**SSD21854025: Lot 124 & 125 DP 757125, Lot 2 DP 550633 and Lot 1 DP 577294, Mitchell Street (HW29), Wee Waa, Wee Waa High School**

TfNSW has reviewed the documentation submitted with the application and provides the following advice:

**Figure 3** Indicative site layout

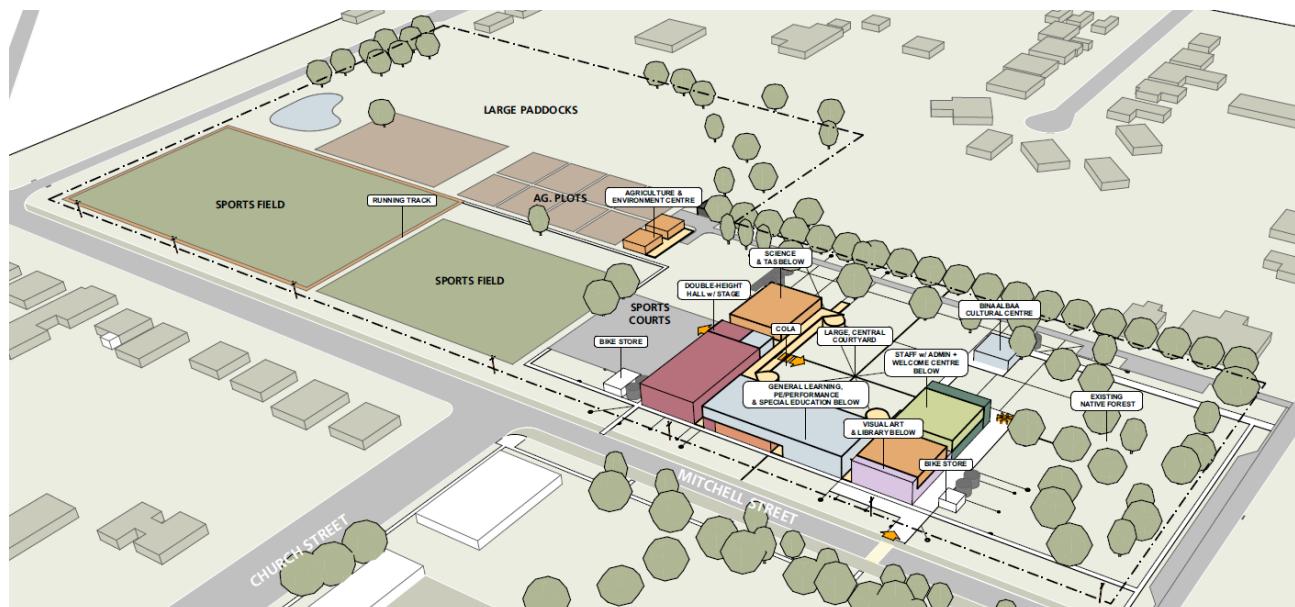
The current proposal provides a pickup drop off bay in George Street in line with the proposed bus zone. TfNSW notes that seven drop off spaces and two bus spaces have been provided in the current proposed design.

The Transport and Accessibility Impact Assessment indicates that 45% of high school students and 6% of teachers are expected to utilize drop off facilities with a 15 minute peak period expected. The proposed design proposed is based on an estimated turn over of 90 seconds for an estimated 68 vehicles in the peak period. TfNSW is concerned that the proposed combined design and the location of the pickup drop off area will result in queuing of vehicles onto the Kamilaroi Highway.

Accordingly, TfNSW recommends that the pickup drop off bay be located separate to the bus zone. The pickup drop off zone should be located within the site boundary with access gained from a local road. Alternatively, the pickup drop off bay should be located on a local road, designed with adequate length to ensure queuing into the Kamilaroi Highway is avoided.

- TfNSW does not support the location of a pedestrian crossing across the Kamilaroi Highway as depicted on the submitted plans. TfNSW notes that the traffic and pedestrian numbers are not likely to meet TfNSW warrants and safety considerations for approval of a pedestrian crossing.

Subject to support by Narrabri Shire Council TfNSW suggests that Kerb extensions, with no pedestrian refuge, designed in accordance with TfNSW Technical Directions, Australian Standard – Manual for uniform Traffic Control Devices and Austroads Design Guide Part 4 Intersections and Crossings be installed on Mitchell Street on the western side of the Mitchell and George Streets intersection to provide a formalized crossing location.
